Application for Removal or Variation of a Condition following Grant of Planning Permission or  
Listed Building Consent

DESCRIPTION Demolition of existing dwelling and construction of 2 no. new dwellings  
LOCATION Century House, Manchester Road, Millhouse Green, Sheffield, S36 9LQ

APPLICATION NO. 2021/0757

CONDITION NO 2 DRAWINGS

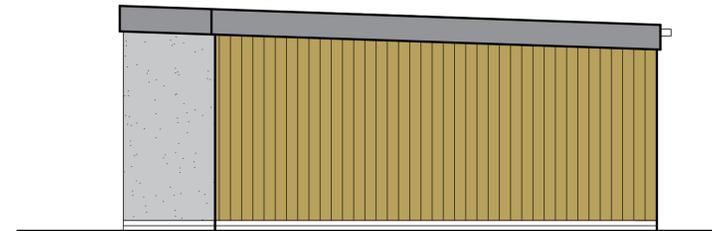
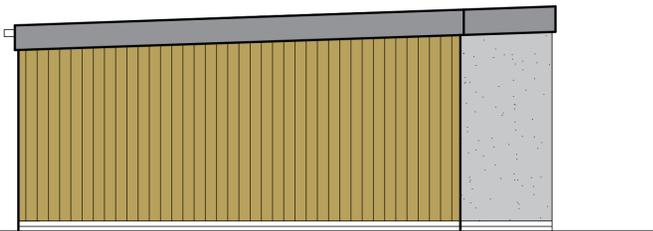
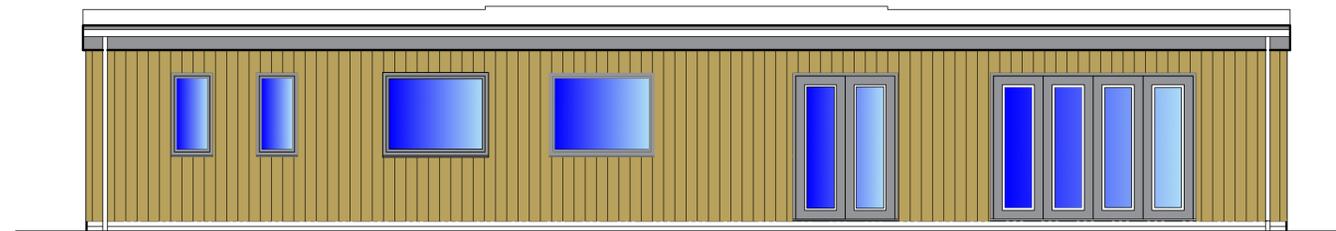
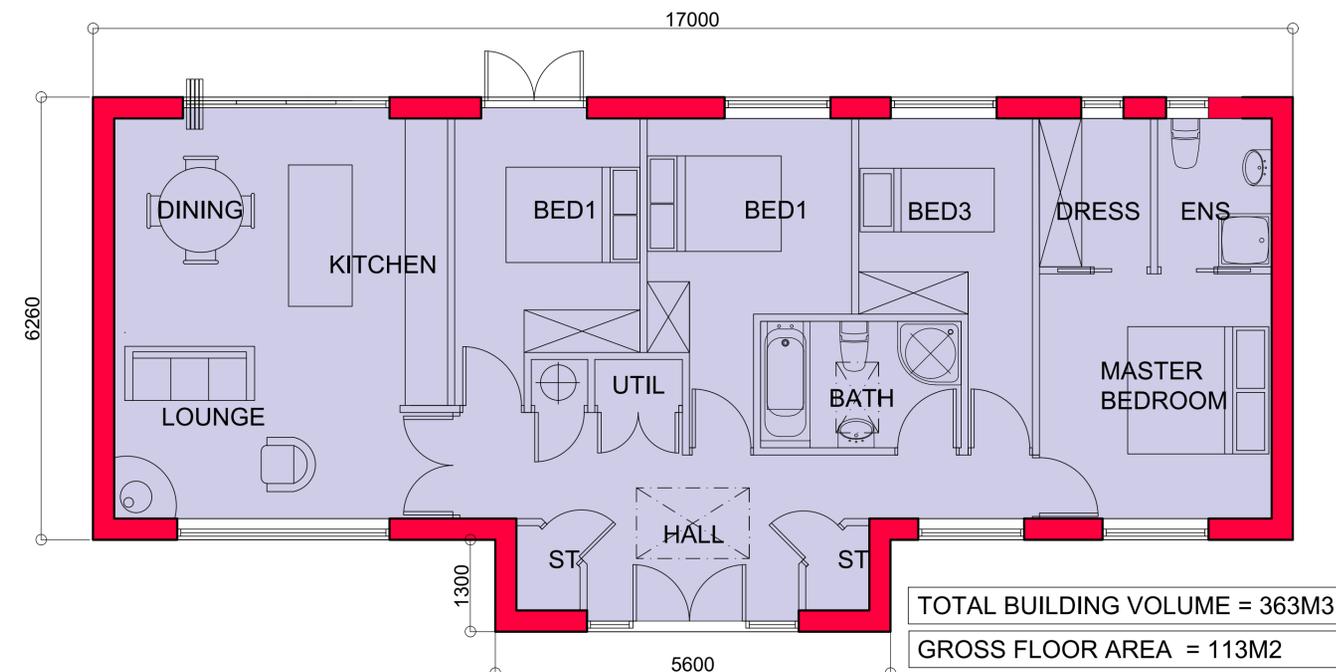
ISSUES WITH SIP PANEL DESIGN WITH OVER HANGING ROOF & CLIENT HAS DECIDED HE PREFERS THE BUILDING WITH OUT THE ROOF OVER HANG

CONDITION TO BE CHANGE WITH REVISED DRAWINGS WITH ROOF OVERHANG OMITTED.
